Neighbour consultation letter pls. upload

DRAWING TITLE
PROPOSED FLOOR PLANS & ELEVATIONS

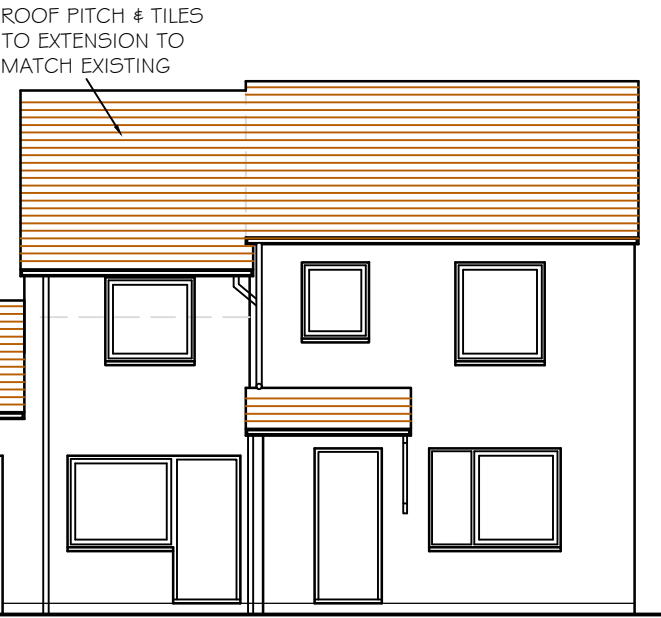
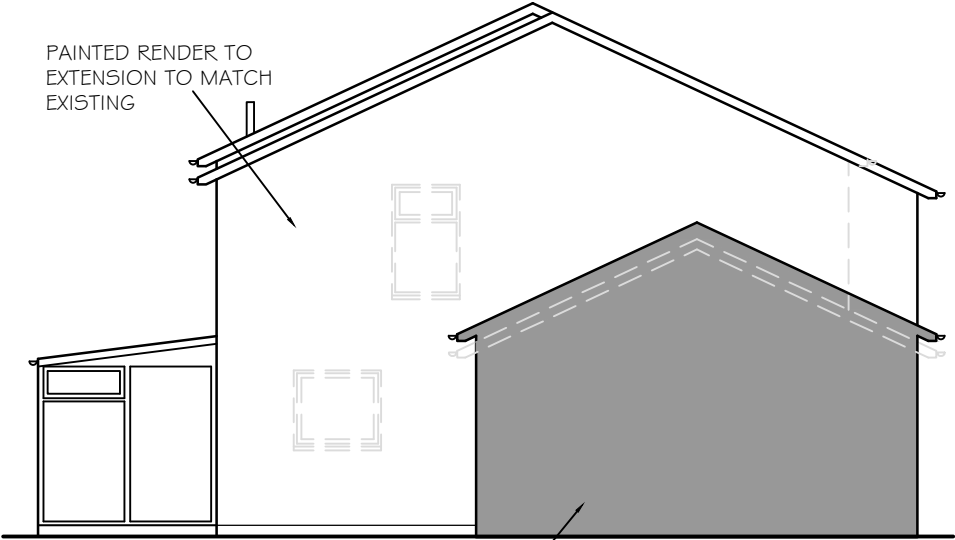
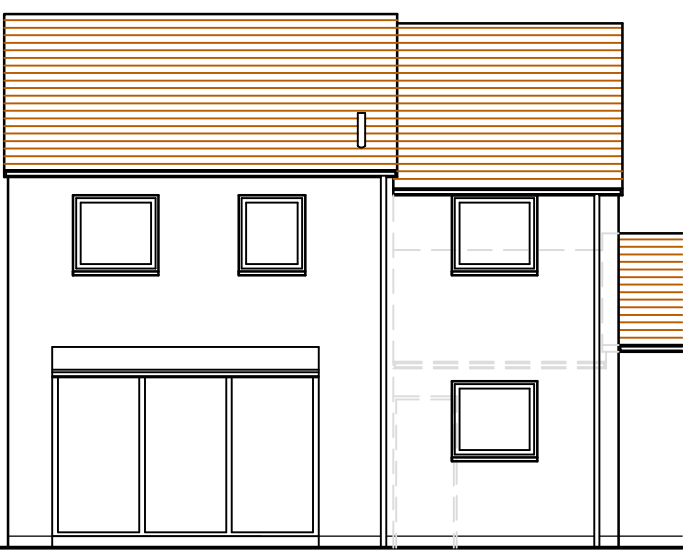
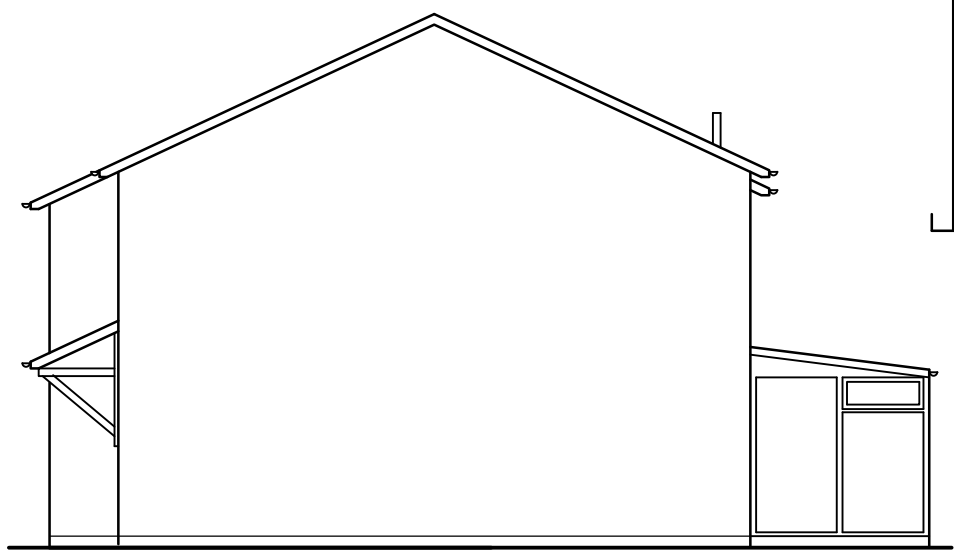
I have seen the plans. The building is proposed to come right up to my boundary. I am concerned that a two storey extension will cut out a lot of sunlight coming into my garden.

PROPOSED GROUND
FLOOR PLAN

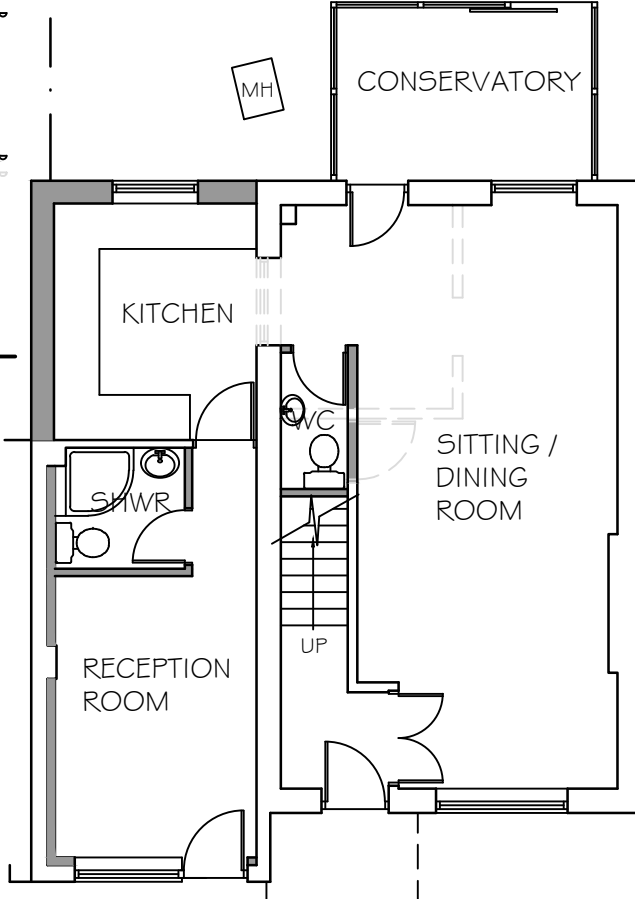
Why 2 front doors? Is it that the extension will eventually become a self contained annex for extra family?
It is theoretically a 6 bedroom house!
